Application by Highways England for a Development Consent Order in relation to the A585 Windy Harbour to Skippool Improvement Scheme

The Examining Authority's Additional Written Questions and requests for information (ExQ3)

Issued on 19 August 2019

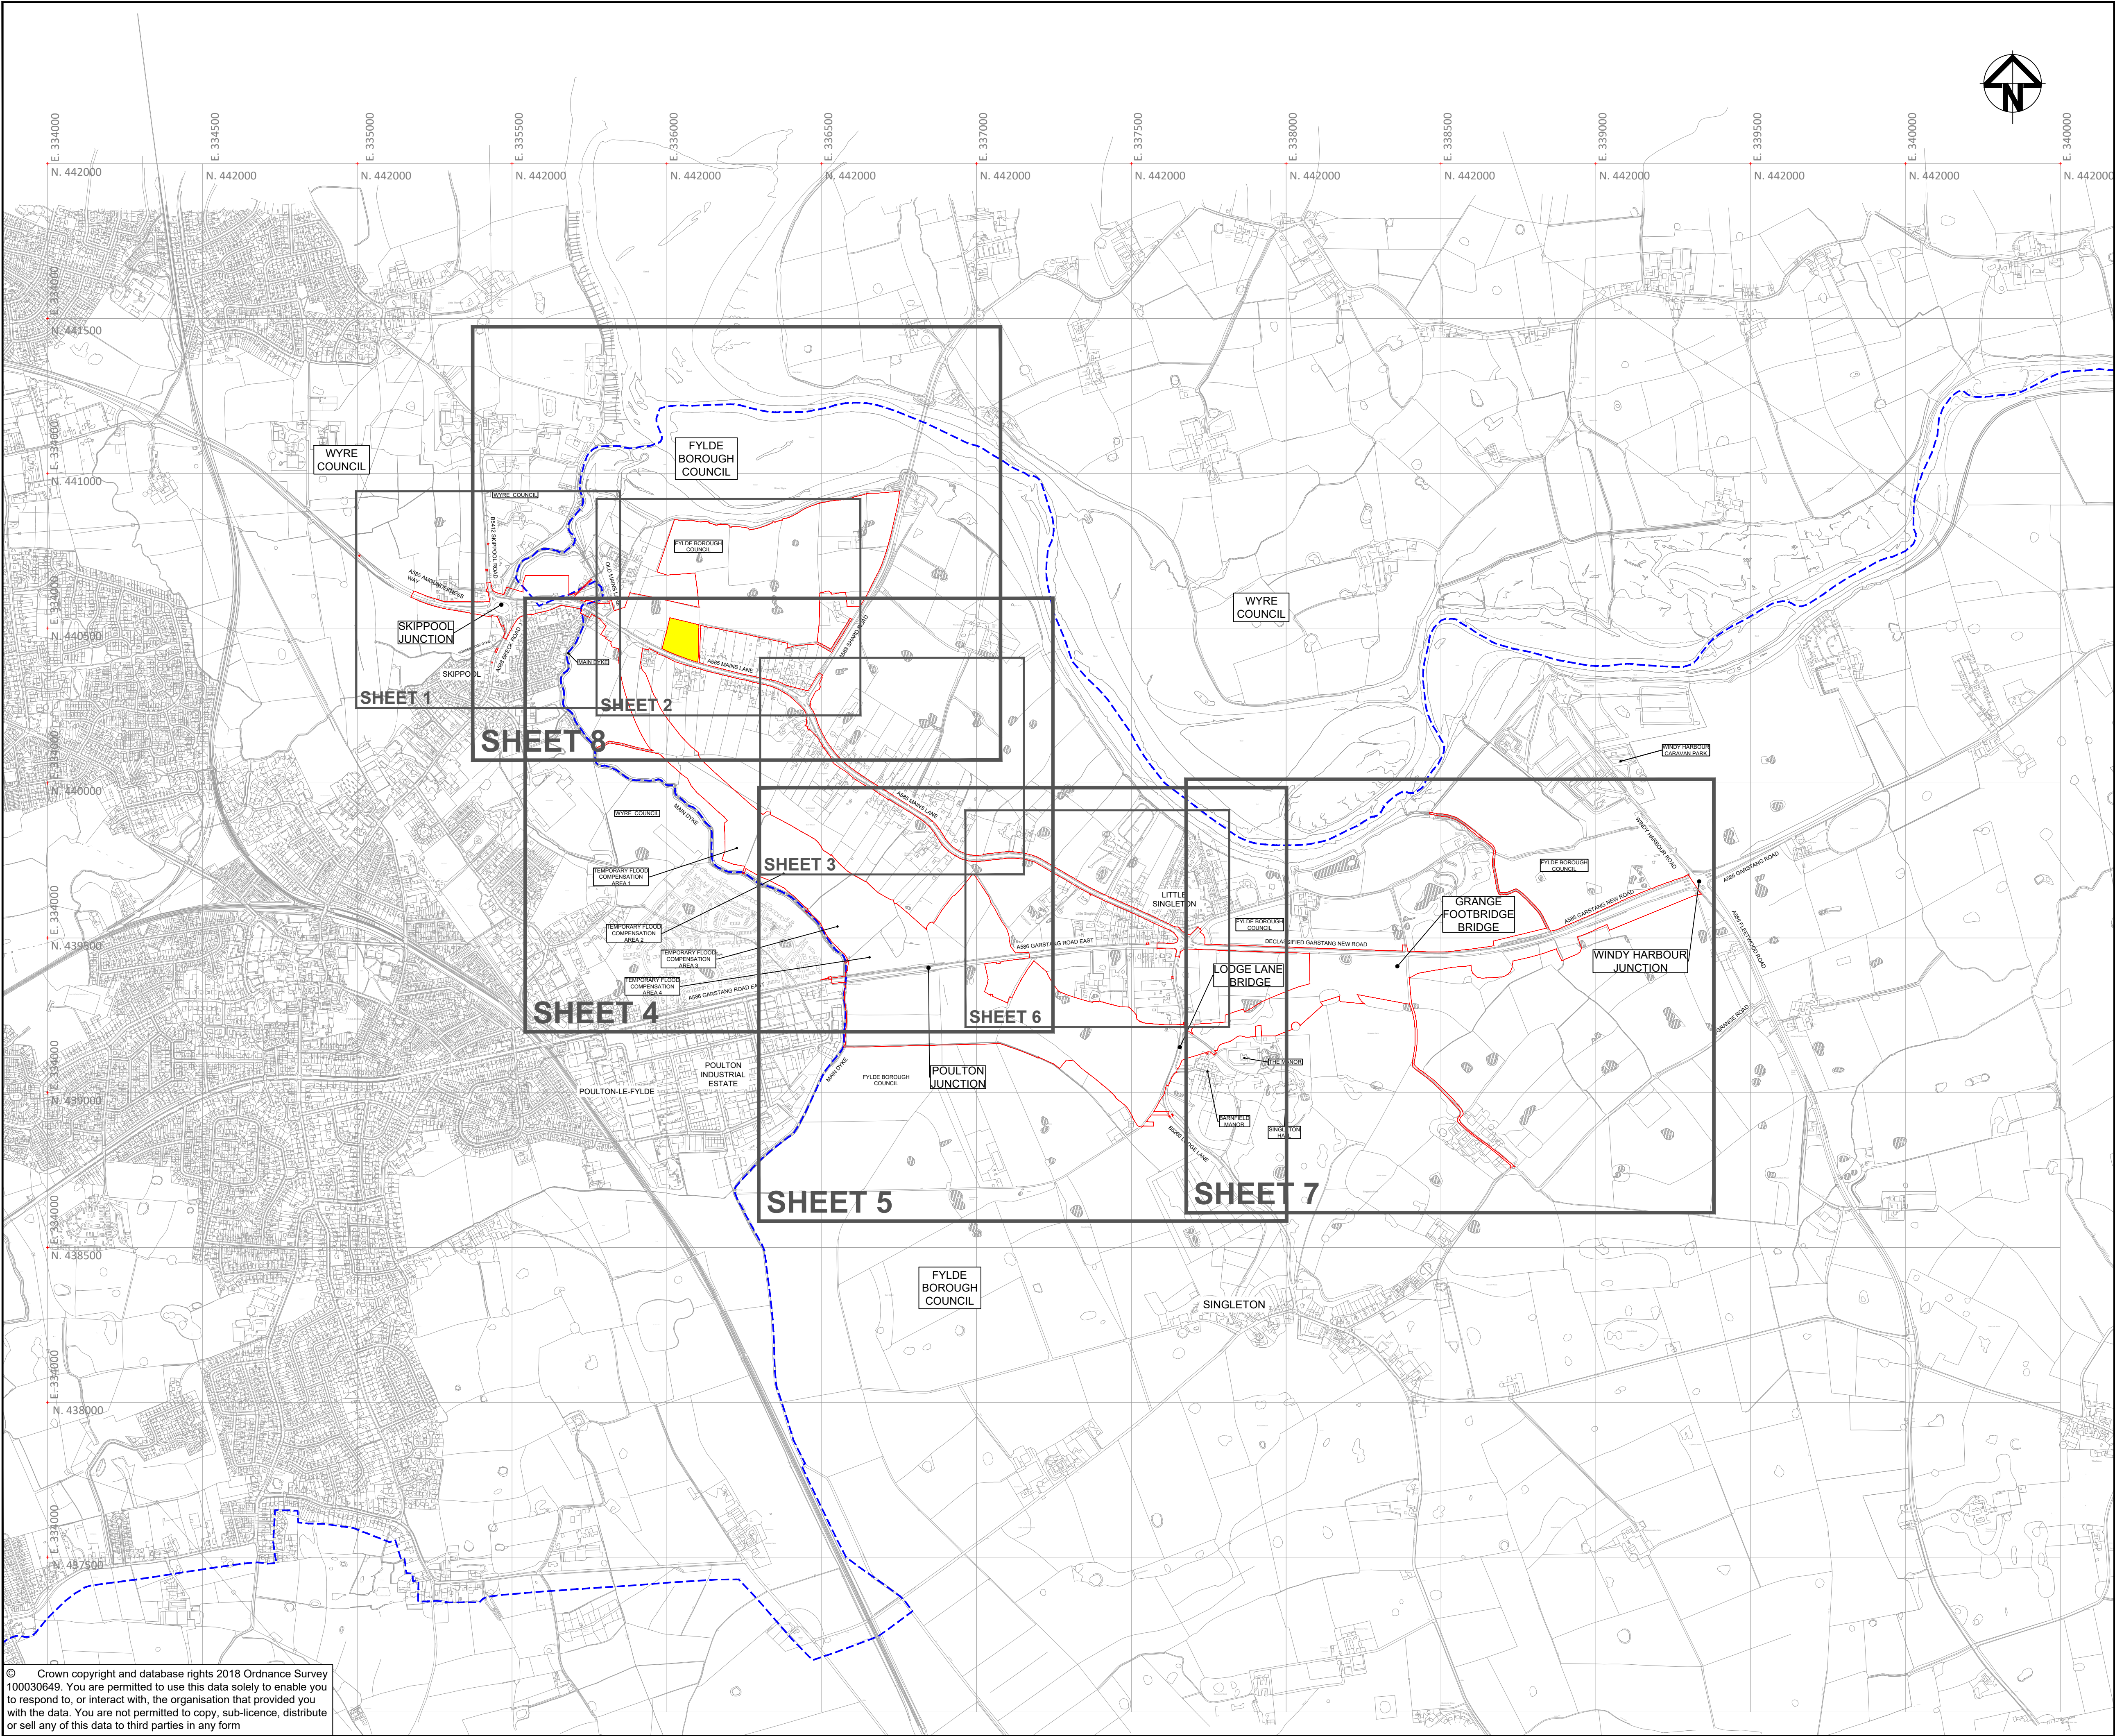
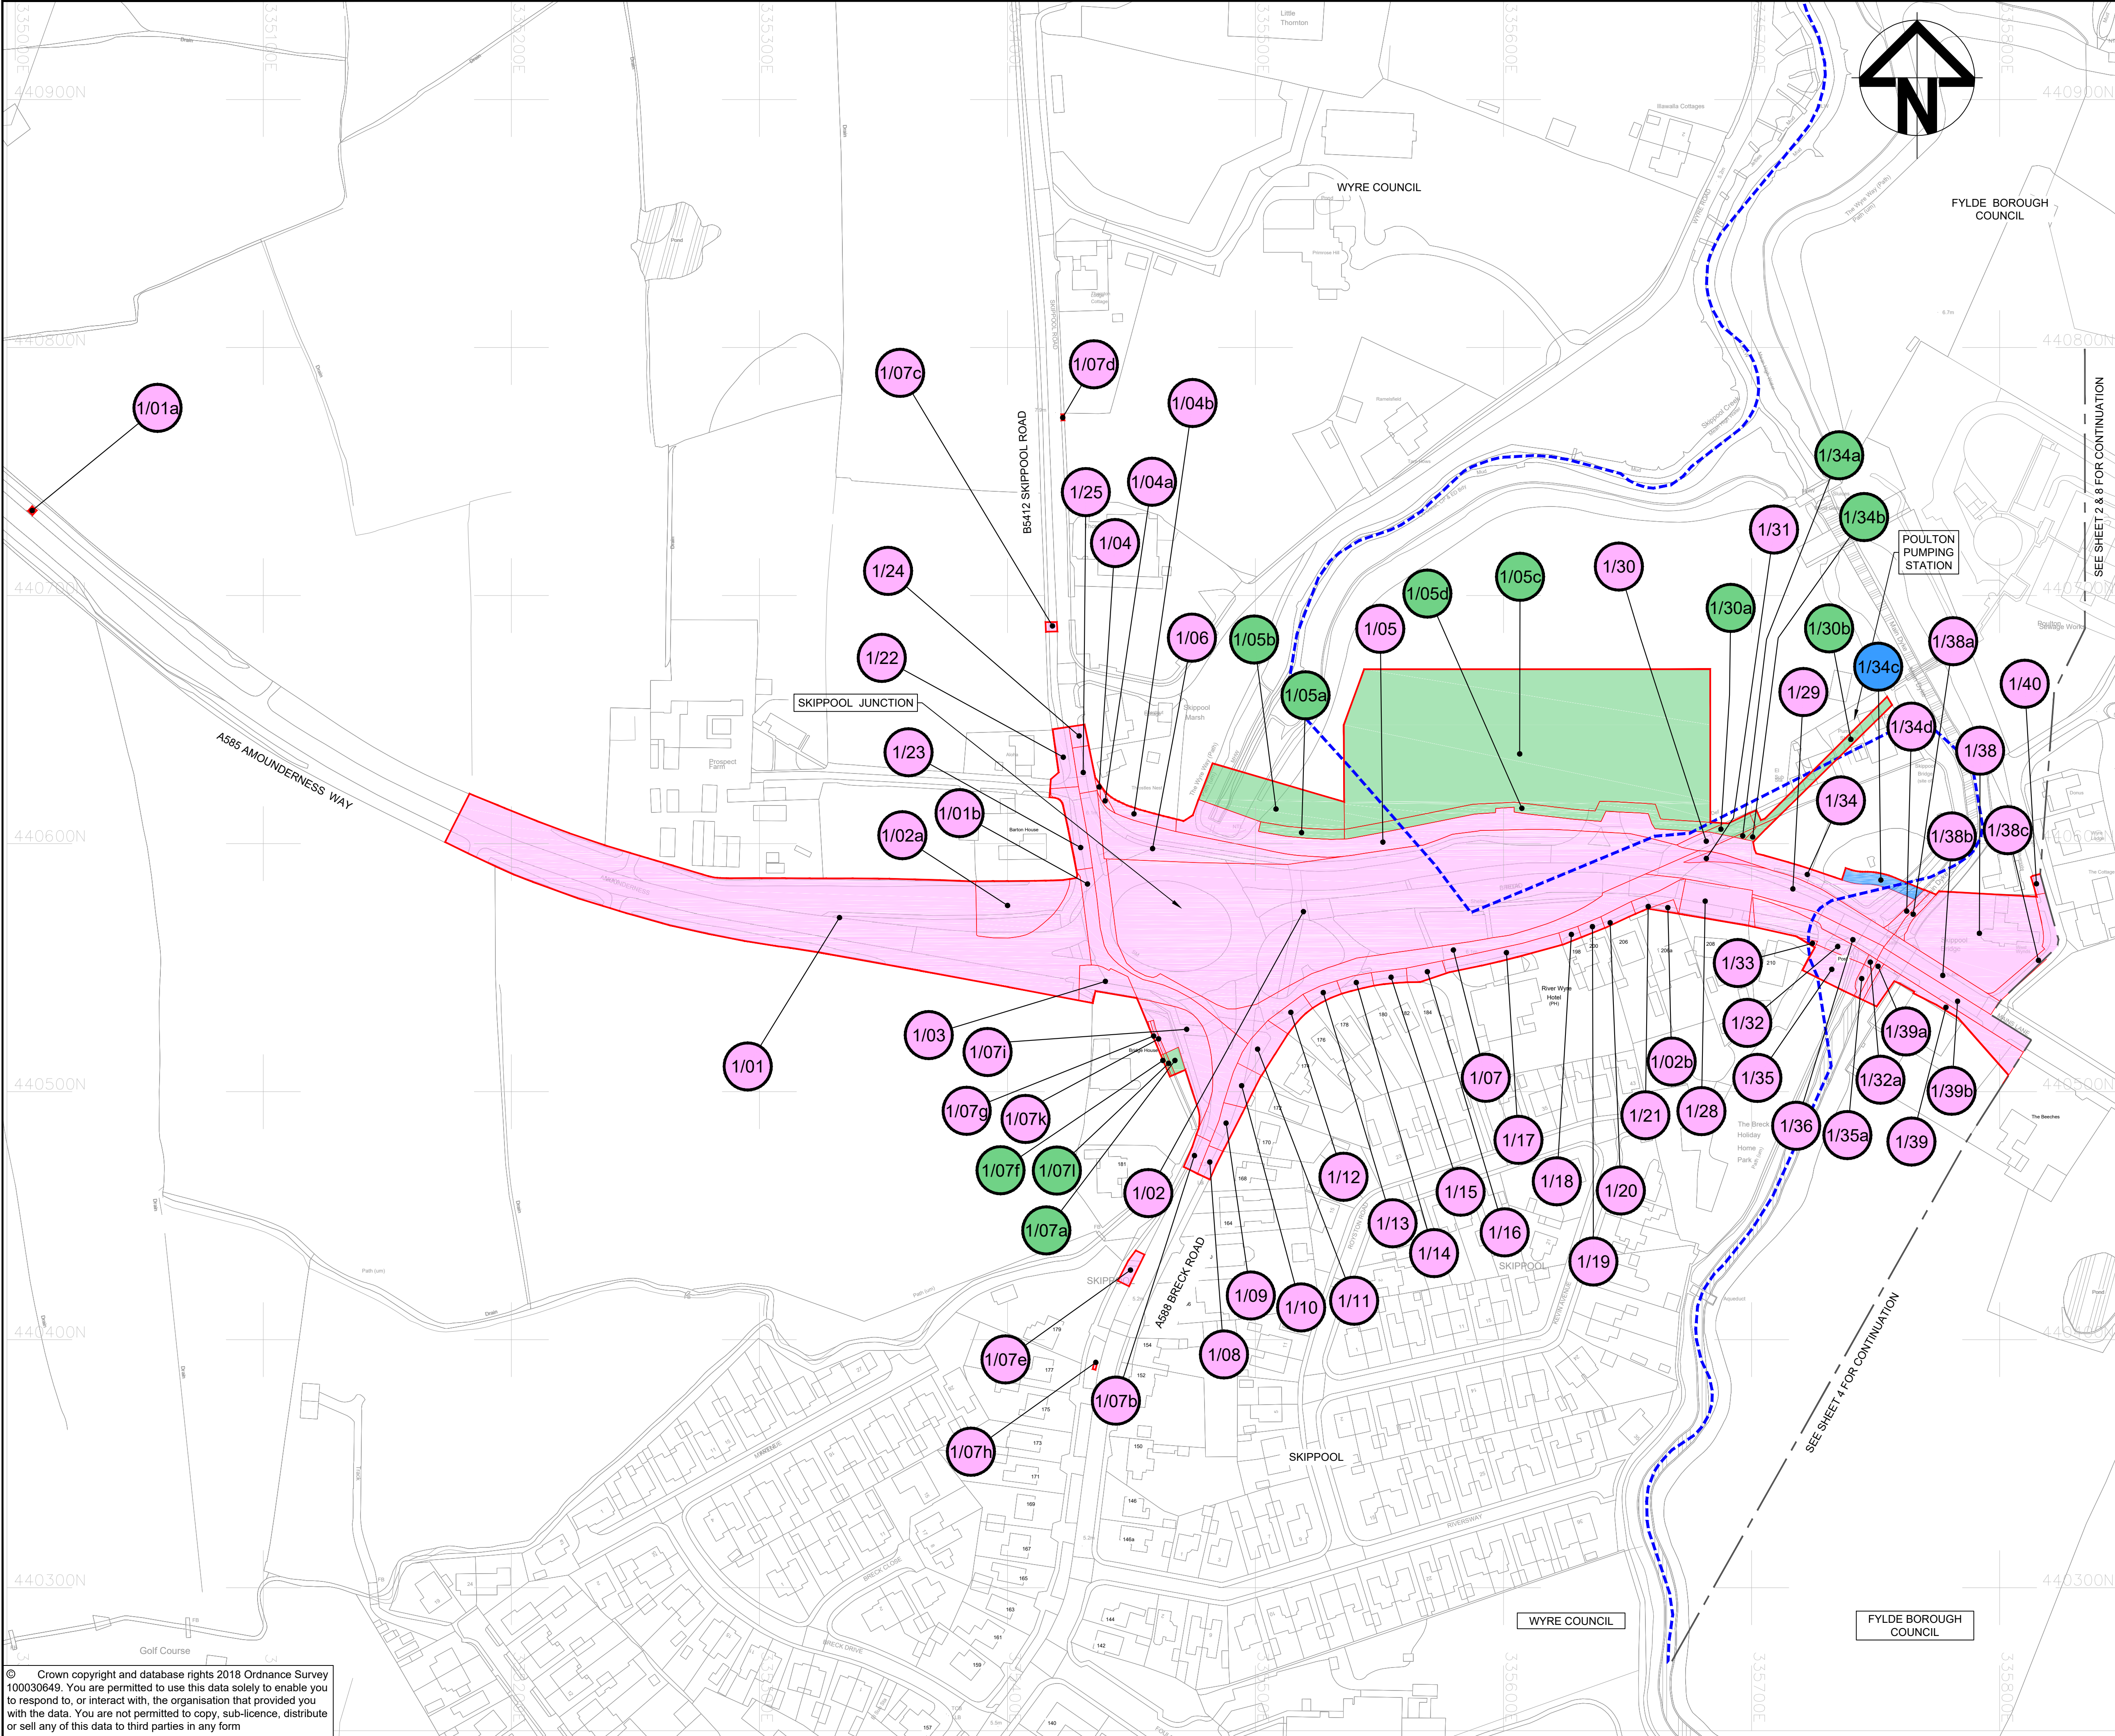
3.2.27.	The Applicant	<p>Area not included in the DCO boundary The ExA still does not understand what the land coloured yellow on the plans is for, or why it is identified on the plans at all. The Applicant has not explained this in their response. If the land is not required for any works or required to be acquired permanently or used temporarily why is it highlighted on the plans? It is also confusing for it to have a red boundary if the intention is for this area to be outside of the draft order limits which are defined by a red boundary. Please explain the reasons for the above?</p>
